**Consultation Response from KC,  
Trees**

**2023/91116 Land off, Primrose Lane, Hightown, Liversedge, WF15**

**Erection of 77 dwellings, with access from Darley Road and associated works**

**Date Responded: 18/06/2024**

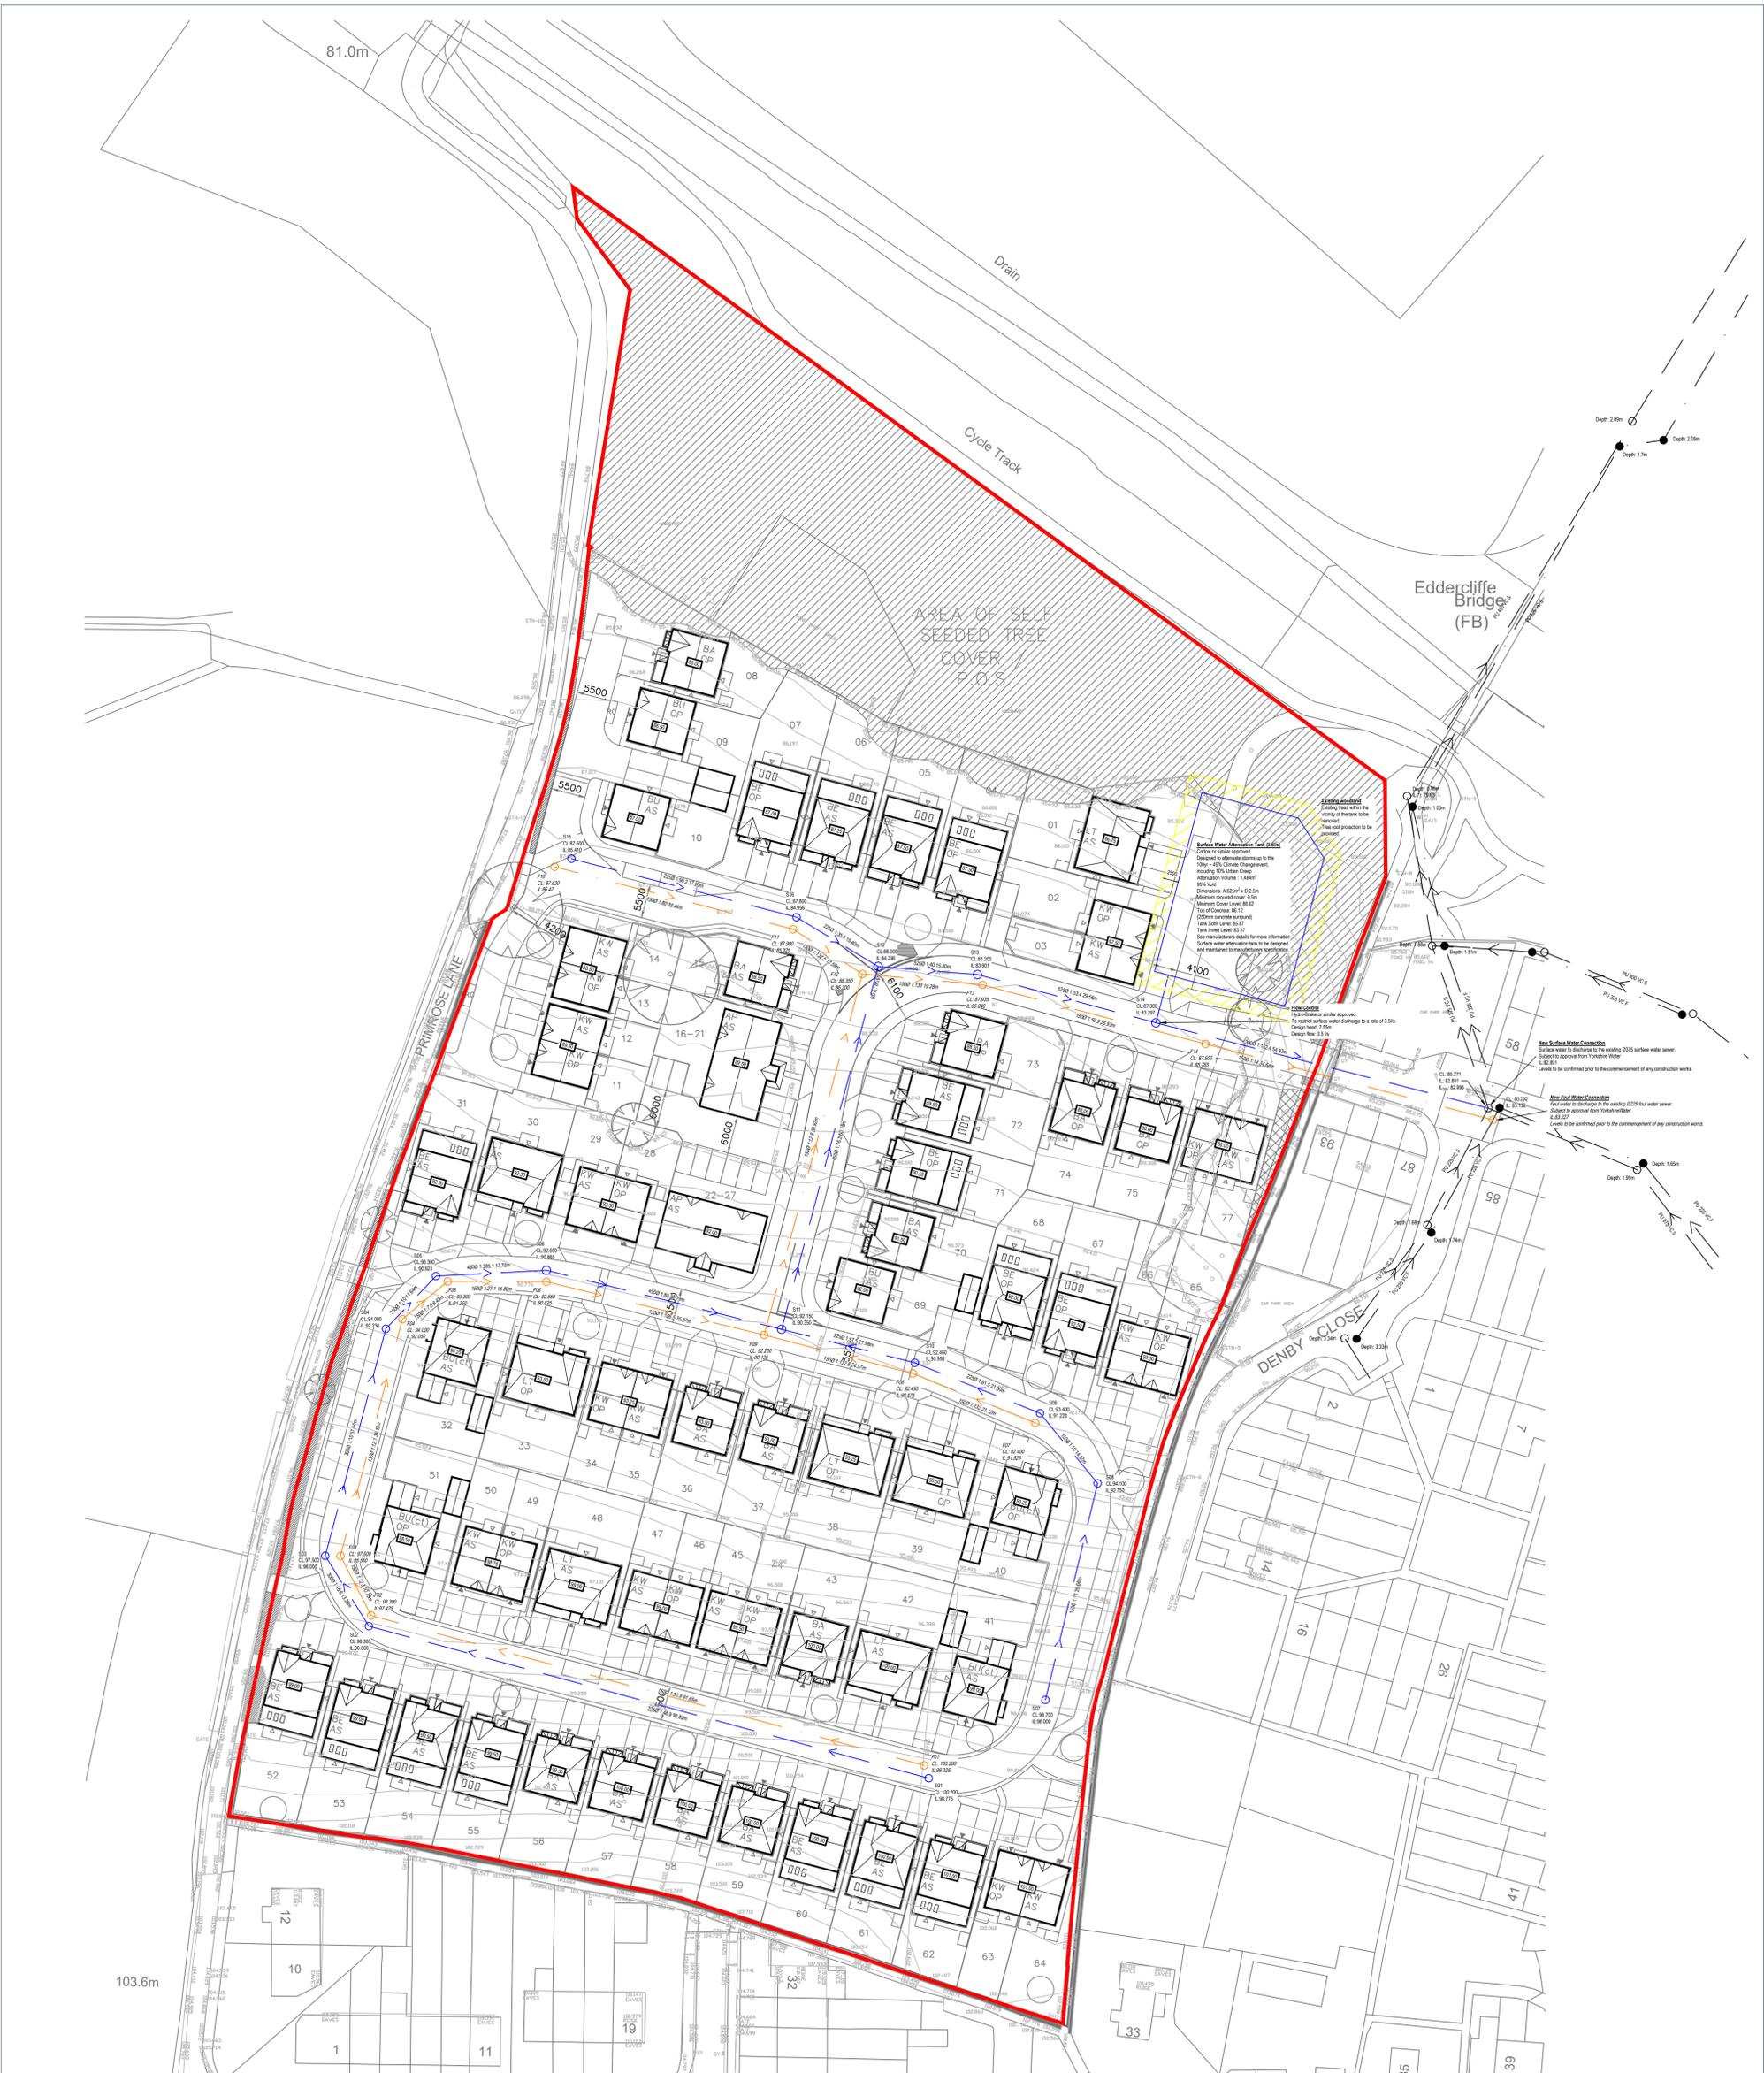
The tree loss across the site is broadly acceptable due to the planting scheme throughout the development. There is still a problem with the proposed water main running through the woodland on the northern edge of the site. This will result in a vast number of trees to be removed in order to facilitate the water main and going forward may result in further tree loss as the retained trees and their roots may pose a nuisance to the water pipe. I would suggest this is redesigned to connect to the current water main at the edge of the woodland and the new main be situated under the road leading from east to west on the northernmost road.

Overall, there is an objection to the proposal from a KC Trees perspective, because the proposal conflicts with adopted Kirklees Council Local Plan LP33 and LP24(i).
